Our ref: NO/2021/113762/01-L01
Your ref: 3/2021/0767
Date: 31 August 2021

**REPLACEMENT TWO STOREY OUTBUILDING
THE BARN BY THE RIVER KENYON LANE LANGHO**

Environment Agency position

section A-A
 0 1 2 3m
 scale 1:50

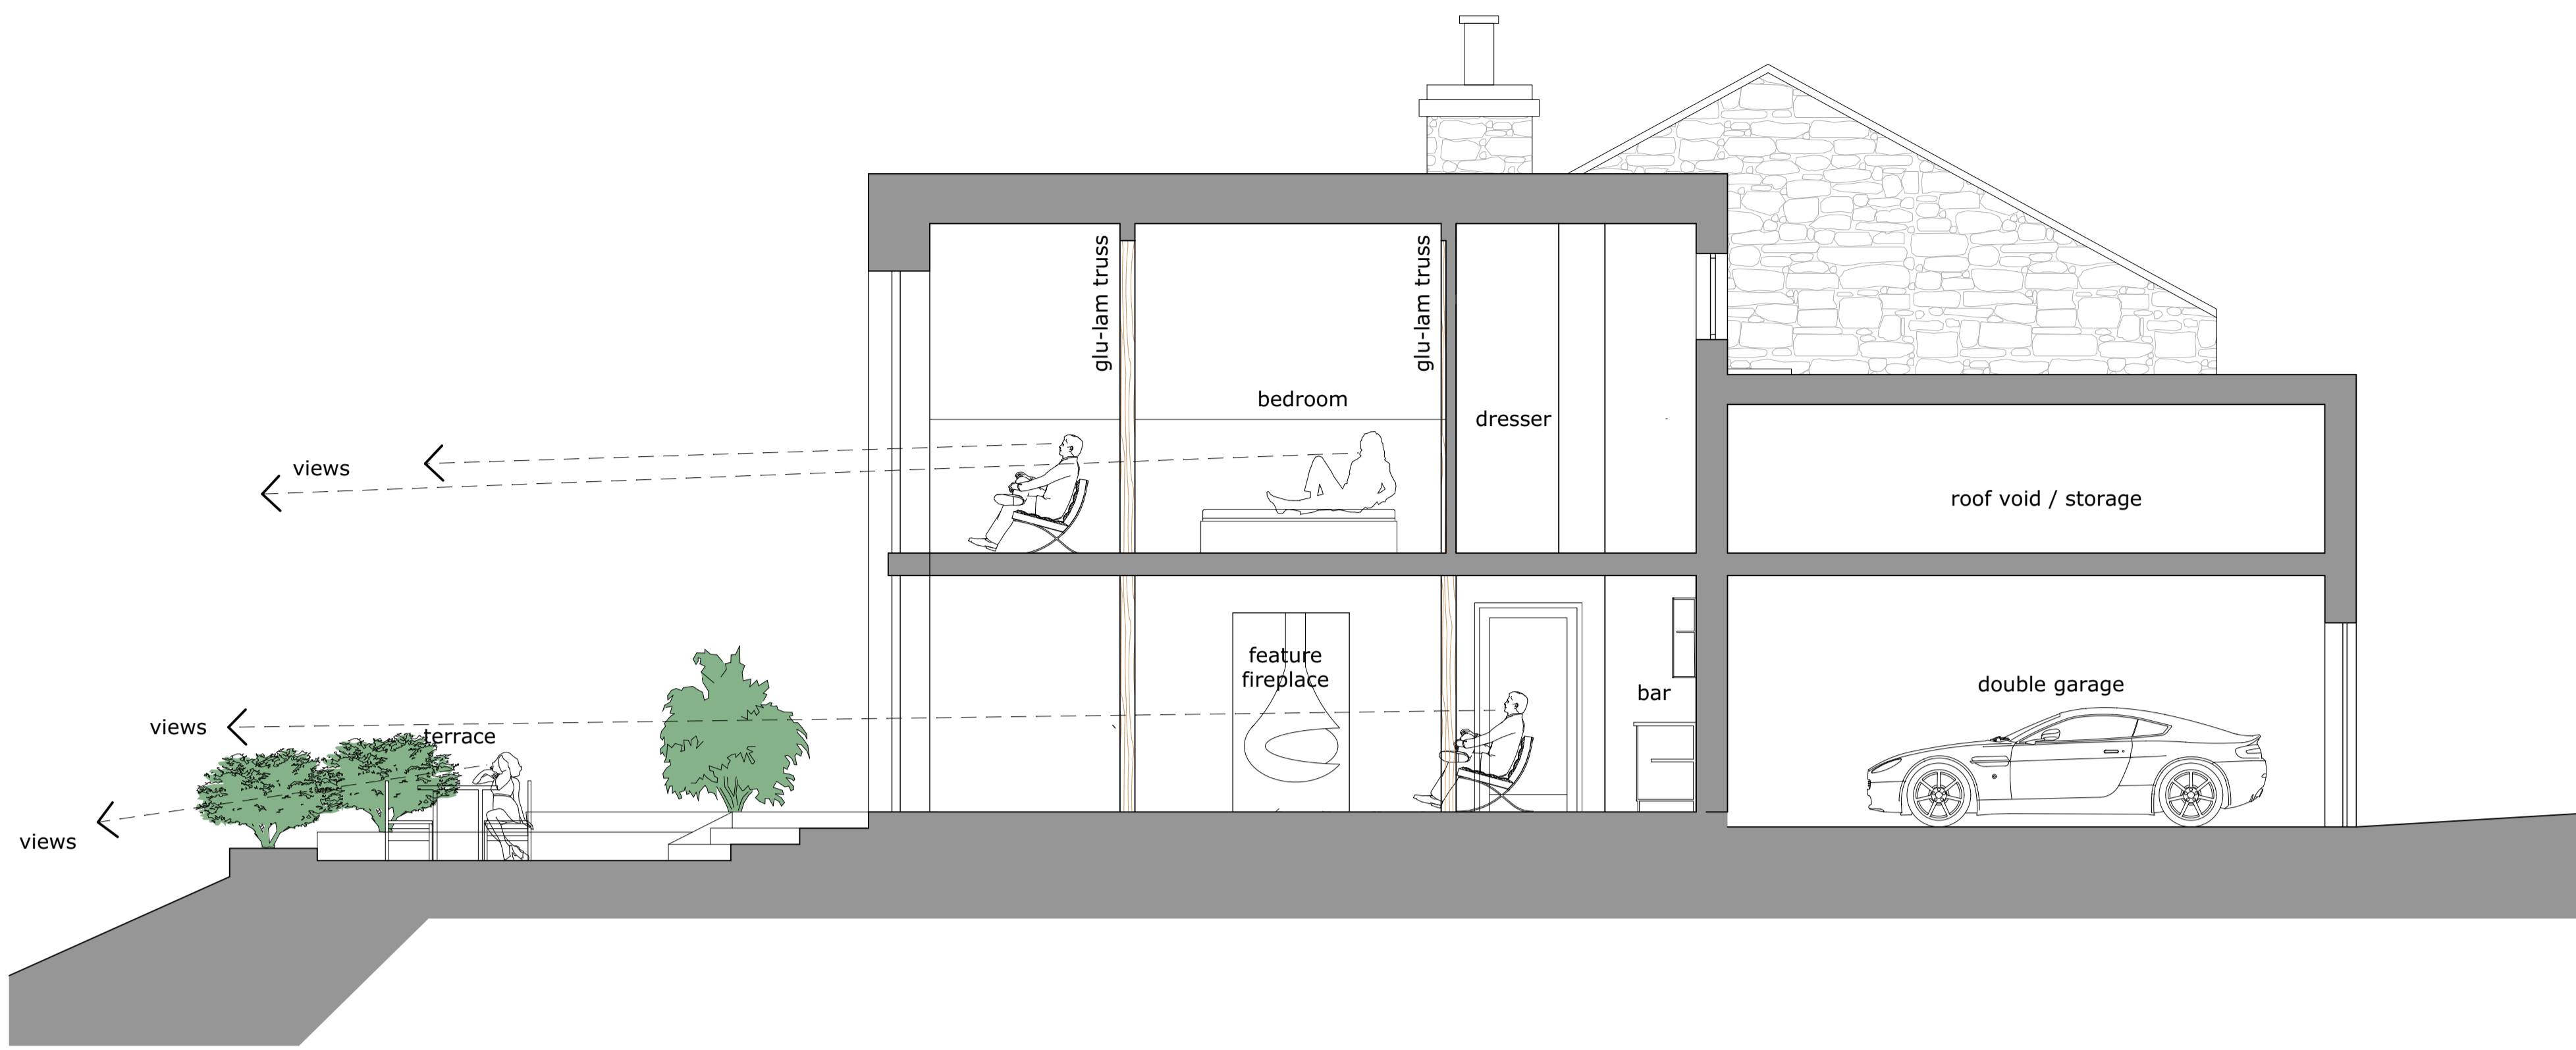
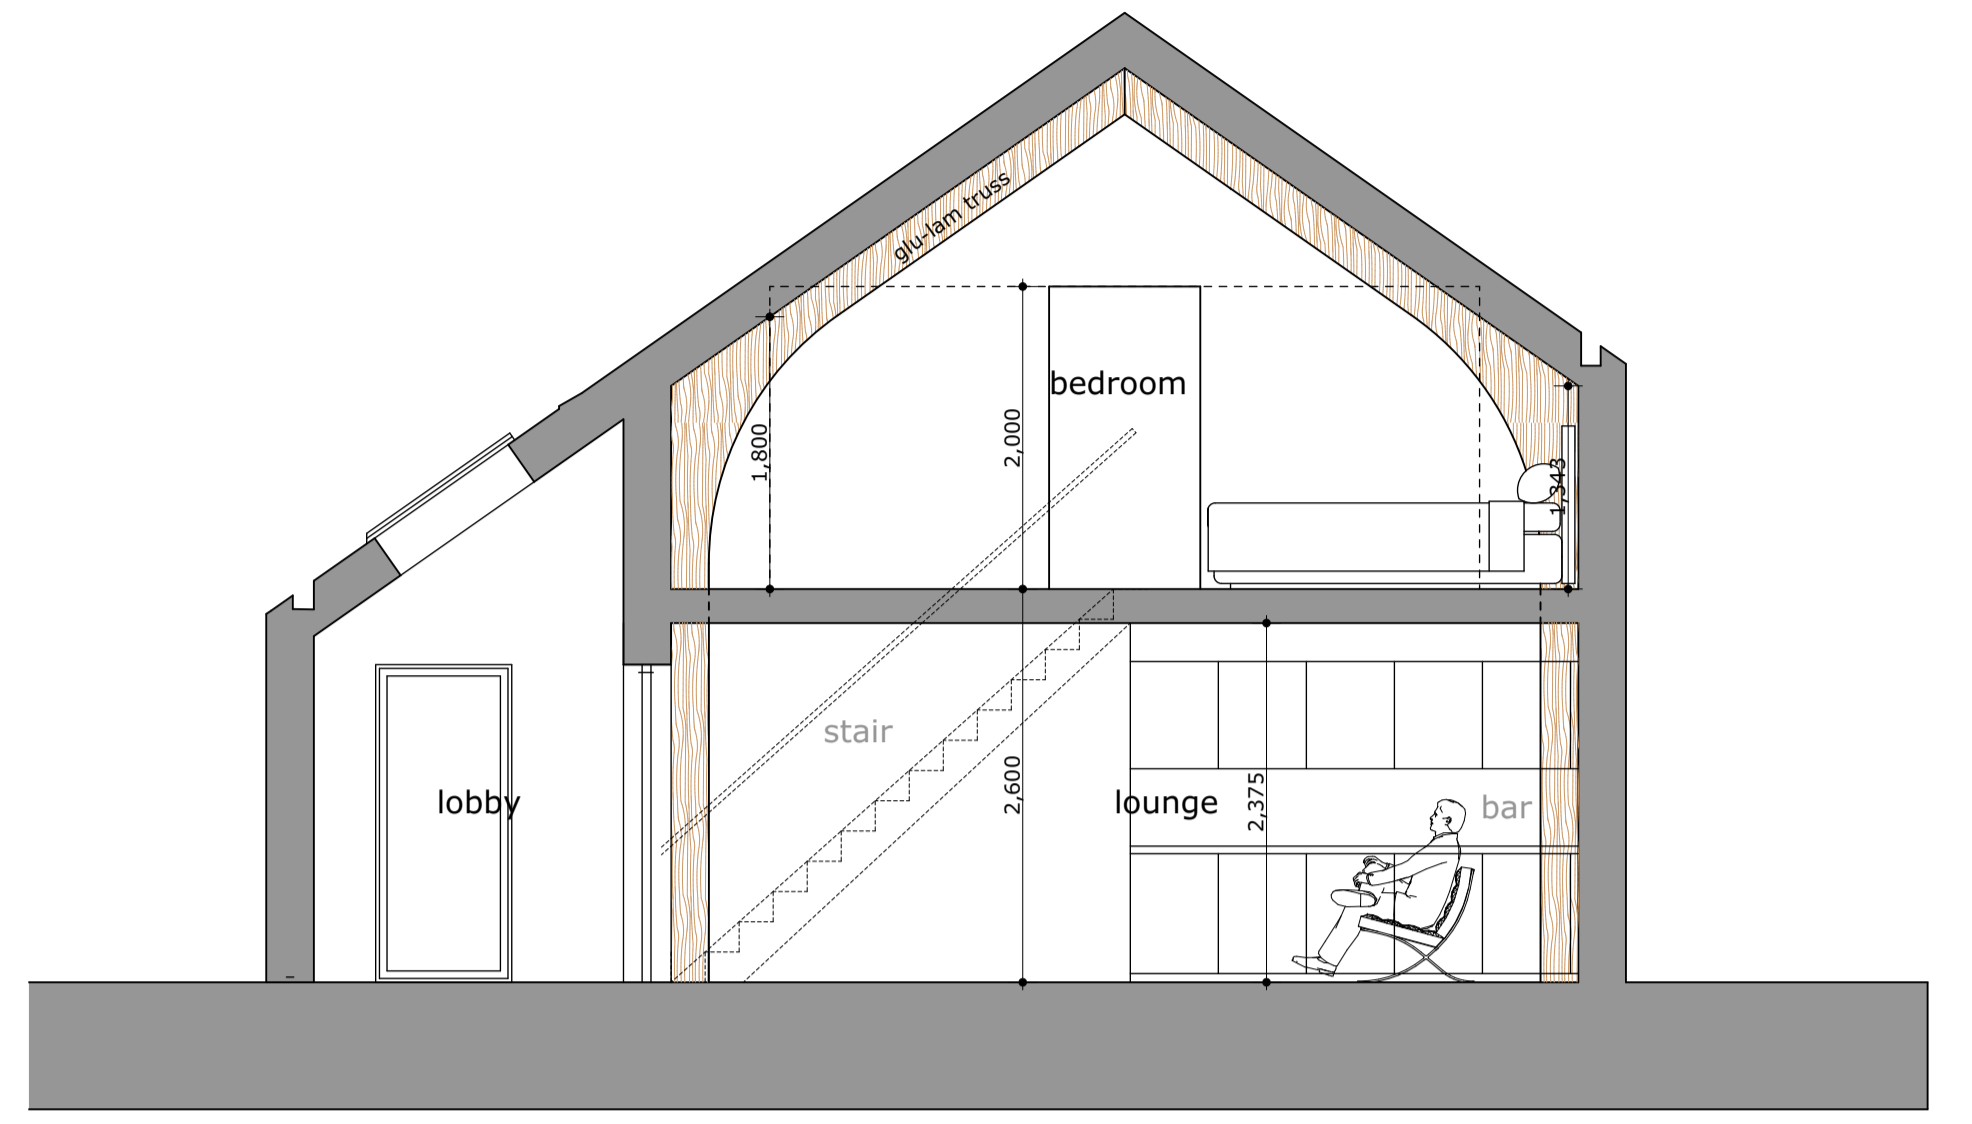
The existing garage building and terrace appear to be located adjacent to the top of bank of the River Ribble. Section AA indicates that the ground levels will be raised within Flood Zone 2 to accommodate the proposed terrace, infilling and reducing the capacity of the floodplain resulting in a potential increase in flood risk elsewhere. We also note that this drawing conflicts with the north-east and south-west elevation drawings which do not show a terrace.

A series of cross sections should be submitted clearly showing:

- The water level in the main river, the top of the bank of the main river, the location of the existing development and the location of the existing decking. The

distance between the top of the bank of the main river and the existing decking should be clearly marked on the drawing.

- The location of the proposed development and decking in relation to the top of the bank of the main river. The distance between the top of the bank and the development (including the decking) should be clearly marked, the minimum distance must also be clearly marked.
- The existing and the proposed ground level between the main river and the proposed development.
